Applicant: Aysha Majid

Proposal: Discharge of Condition 3 (windows & doors) , Condition 5 (timber cladding), and Condition 7 (stone sample panel) of 21/00438/LB

Case Officer: Shona King

TITLE:
Window W1, W2 & W3

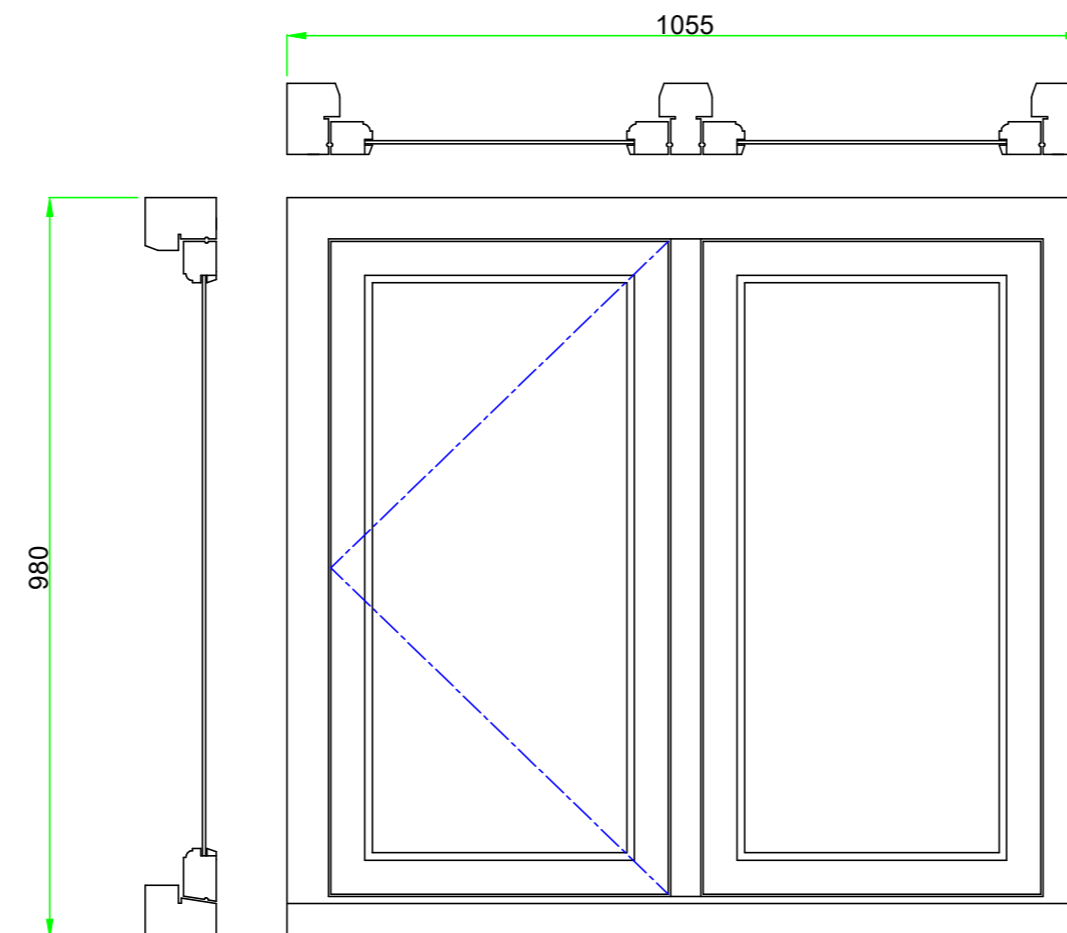
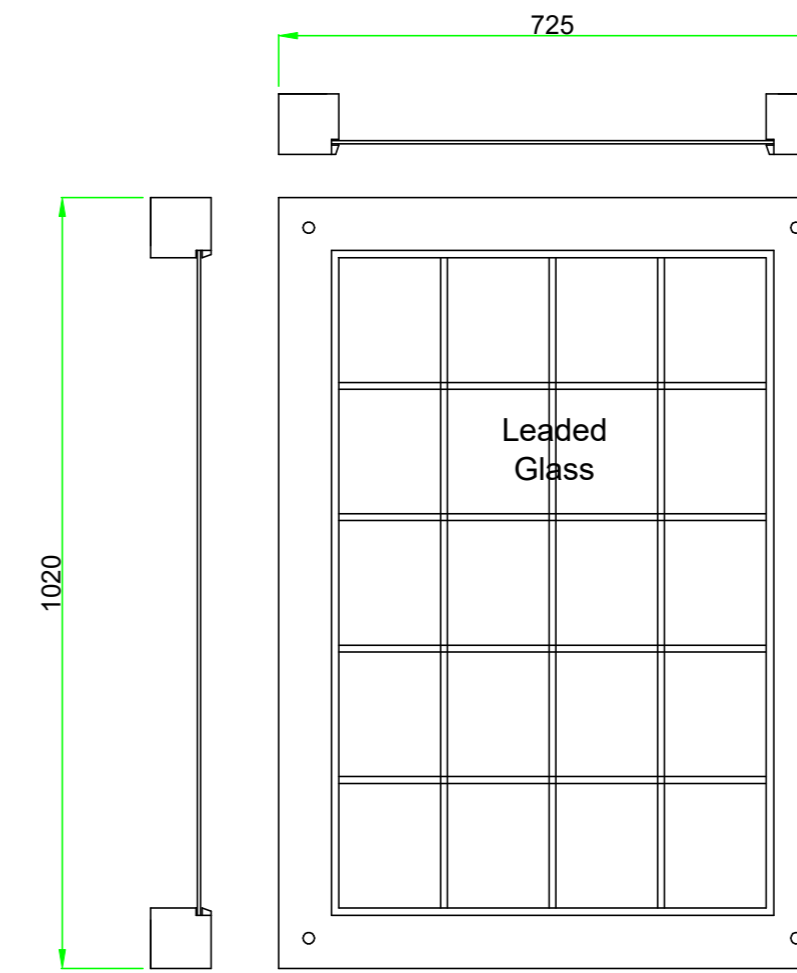
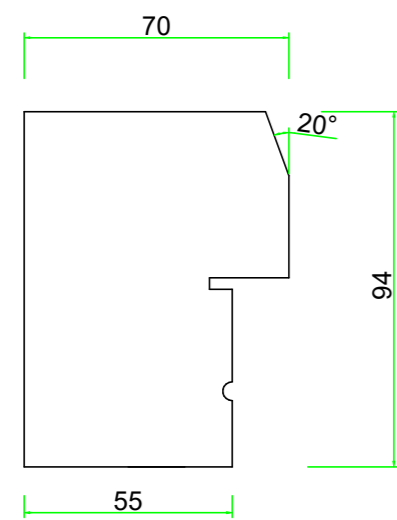
5.1. Condition 3 requires the submission and approval of details of new doors and windows. The details that have been submitted are considered to be acceptable. Whilst the small window adjacent to the front door is inappropriate for a listed building due to the leadwork being applied to the glass rather than true leading being used, this is a like for like replacement and as such we cannot seek betterment. Likewise, the proposed front door is not of a detailed design that reflects the character of the building it too has been replaced on a like for like basis. Glazing bars have been added to windows and omitted from the side lights adjacent to the front door in accordance with the Conservation Officer's comments. The amended details are therefore considered acceptable.

Drawing Nos: D1, D2, D3, D4 (showing glazed panels without glazing bars), W1 W2 and W3 and Kitchen Window.
